East Park Energy Solar Project

DCO Application 010141

Submission by Phil Wayles on the Applicant's A1/B645 Junction Technical Note

Submission by Phil Wayles on the Applicant's Updated Outline Construction Traffic Management Plan (oTCMP)

© Crown copyright and database rights 2025.
Ordnance Survey AC0000808122

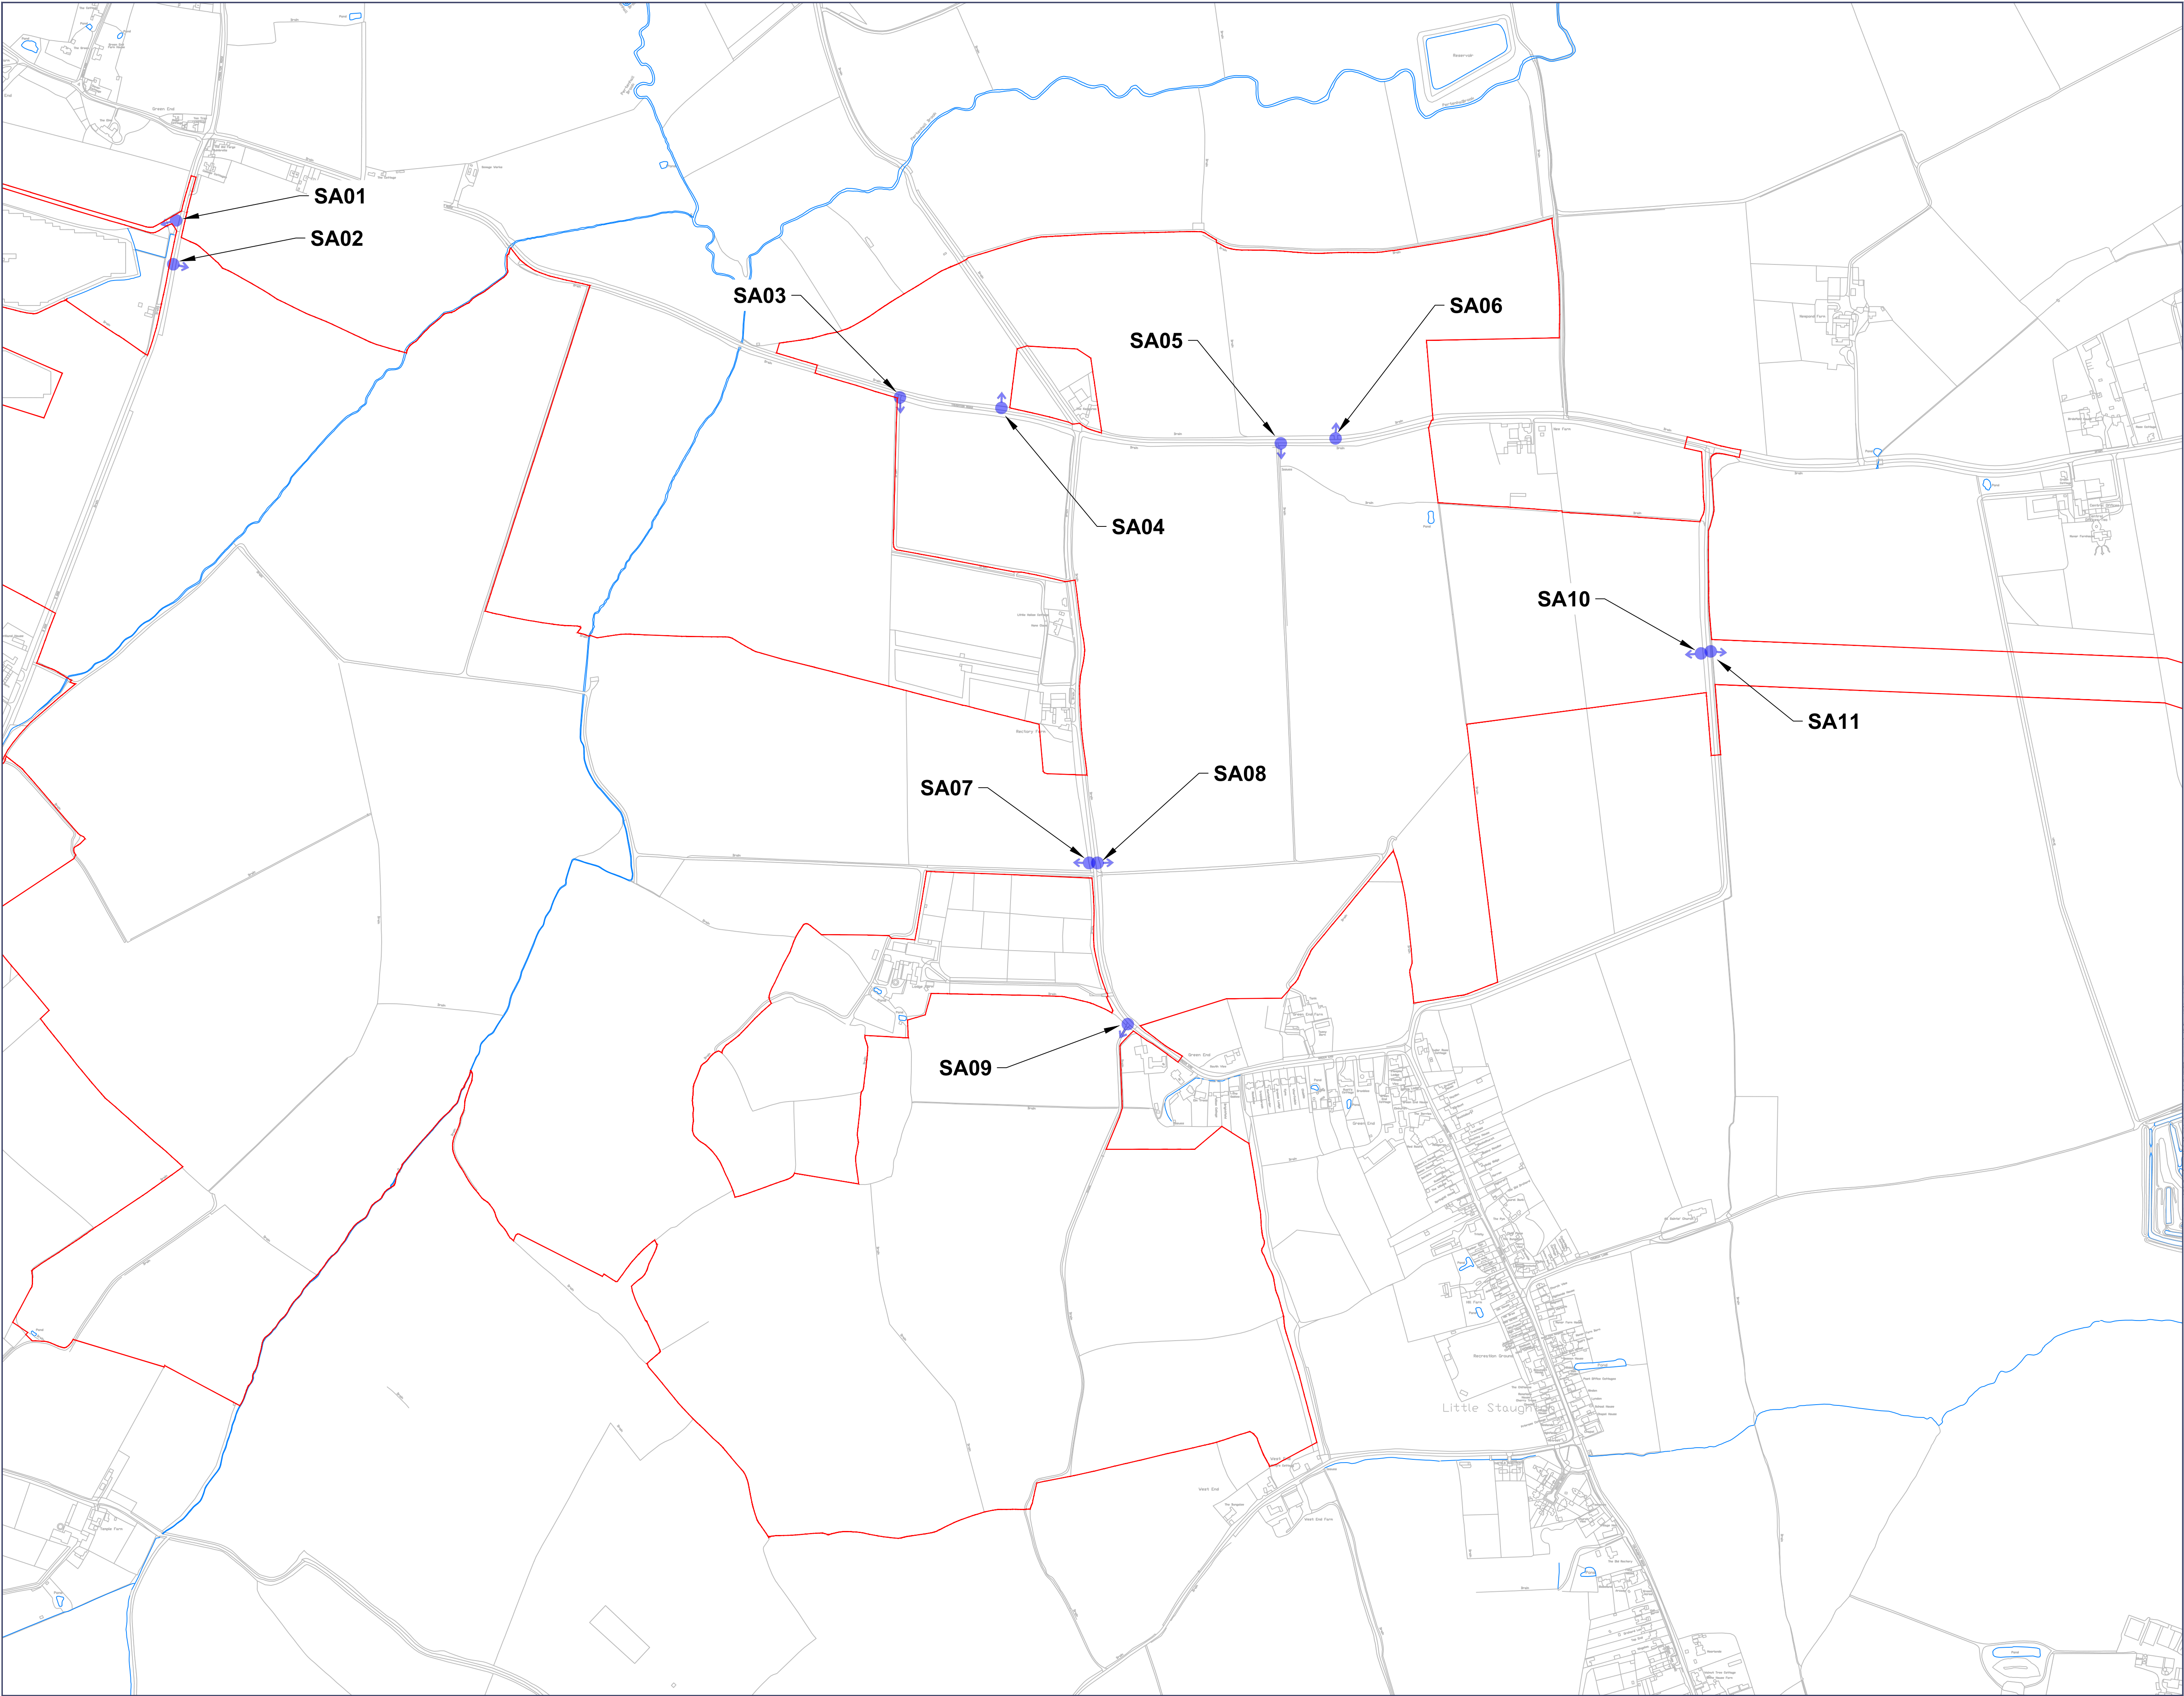
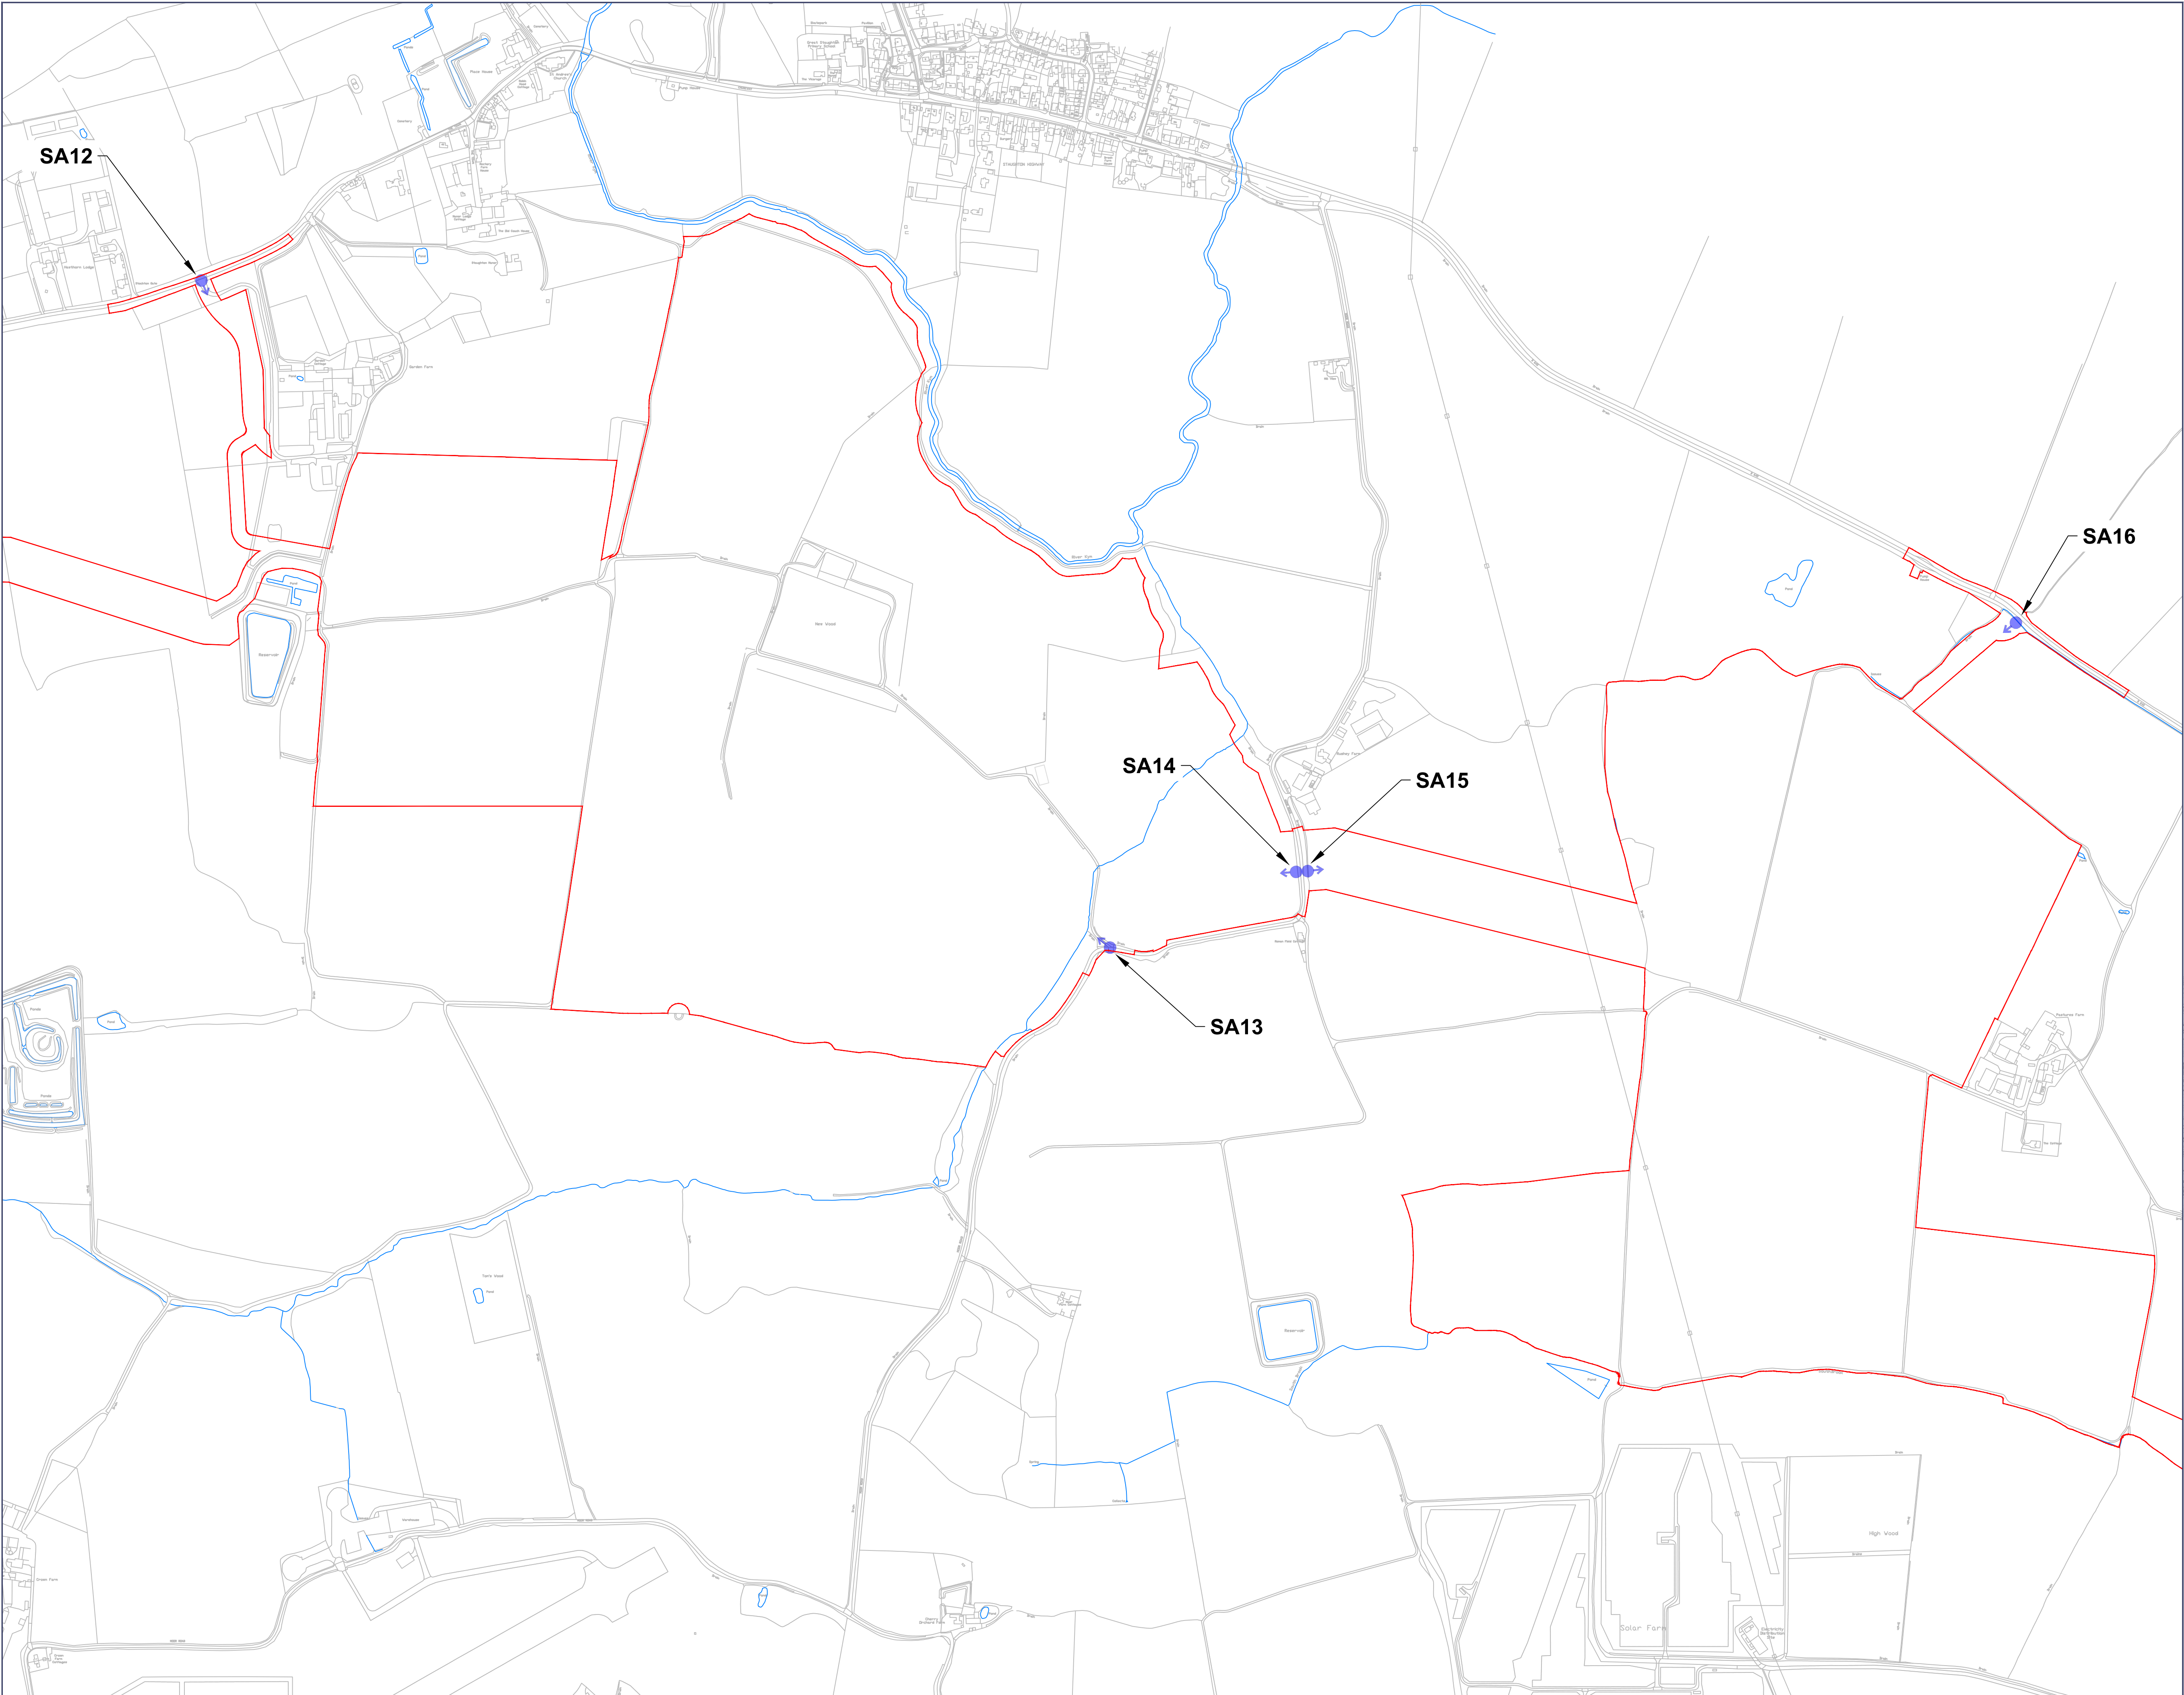
Para 5.1.11 states "*Site B also has a number of site access junctions which require construction traffic to use short sections of the public highway along Great Staughton Road (SA03, SA04, SA05, SA06) and Green End (SA09).*" Also with reference to Para 5.2.1 and 5.2.2, the Applicant's traffic-flow diagrams appear to assign only minimal construction vehicle movements to the SA03–SA06 Great Staughton Road accesses and SA09 at Green End, despite those accesses serving substantial areas of Site B proposed for solar panel development and two of the satellite compounds. The Indicative Site Access Drawings in Appendix D also include swept path tracking diagrams for these accesses. The application does not transparently explain how the

site areas accessed by SA03, SA04, SA06 and SA09 can be constructed with such limited access movements especially as road widening is required at some locations. This creates uncertainty as to whether the traffic assessment materially understates localised construction activity on Great Staughton Road and Green End Road. The satellite compound near Green End should be accessed by an internal haul road, rather than by public highway and site access SA09. This emphasises the oCTMP does not explicitly and clearly set out which existing roads will be used by construction traffic, nor does not show comprehensive details for as requested by the Local highways Authorities and several IPs. A Construction Traffic Permitted Routes / Restricted routes must be prepared for the whole area bounded by the A1, A14, Bedford to the south and B660 / Swineshead Road to the west.

Para 5.1.13 has been updated to “*Minor road widening works will also be required along Spring Hill Road, and potentially Great Staughton Road, to facilitate the two-way movement of HGVs between access SA12 and access SA10 during the construction phase.*” As described at the ISH, this requires HGV construction traffic to travel on sections of Great Staughton Road and Spring Hill Road between these 2 accesses (SA10 and SA12) rather than use an internal haul road between Sites B and C. The change to use a section of the public highway was introduced in the Stat Con documentation, although difficult to interpret. At Non-Stat Con, the Applicant intended to use the internal cabling corridor for temporary construction access (haul road). It is illogical and inappropriate to use and widen the existing public highway when a perfectly sensible alternative exists using an internal haul road to be built along the cable route between Sites B and C as shown on Figure 15 - Proposed Construction Access Strategy in Appendix C (see extract below). This plan indicates there is a temporary haul road along the cabling corridor route which is due to be removed post- construction. Mandating use of this section of temporary haul road would improve safety and limit damage to the existing roads by keeping large and heavy site vehicles off the public highway. Furthermore, there would be further disruption to traffic during the construction of the widening works, and this section of the public highway would be also used during the operational replacement works and decommissioning works. This disruption also applies to the road widening works required at several of the new proposed site accesses to accommodate the HGV swept path tracking shown on the Indicative Site Access Drawings.

Appendix D: Indicative Site Access Arrangement Drawings has been added. These show geometric design parameters for each access and crossing. Visibility splays and swept path tracking for rigid and articulated HGVs. The access / crossing designs, existing carriageway widths and fencelines are based on OS Mastermap data. The design should be based on topographical survey data, so the design details are based on accurate road location / width, roadside drainage features, road furniture such as traffic signs, trees and hedgerow position and width. These drawings therefore do not accurately show the extent of works and greater lengths of road widening and hedgerow trimming/removal to achieve the necessary visibility splays. The latter point was raised by the local highway authorities such as BBC in their LIR at Section 11.17 a) iii. The extent of hedgerow removal is already understated in the environmental assessment and impacts of the BNG calculation. Additionally, and as set out above, Sections 5.4.2 and 5.4.3 say the visibility splays at each proposed access are Design Manual for Roads and Bridges (DMRB) compliant. This requirement was requested by BBC at Section 11.17 (Matter 50) and this section highlighted that DMRB visibility splay standards were more onerous than those using Manual for Streets (MfS) criteria. However, some plans in Appendix D still show visibility splays including for Accesses SA14, SA15, SA17, SA18, SA19 and SA20 designed to MfS standards. This potentially makes the access less safe and would require greater lengths of hedgerow removal or trimming.

The very fact that some roads need widening (including to construct several site accesses) proves this local road network is unsuitable for the intended construction vehicles. Also, details are not provided for the traffic management arrangements and traffic diversion routes during construction (including to build the accesses and widen roads).
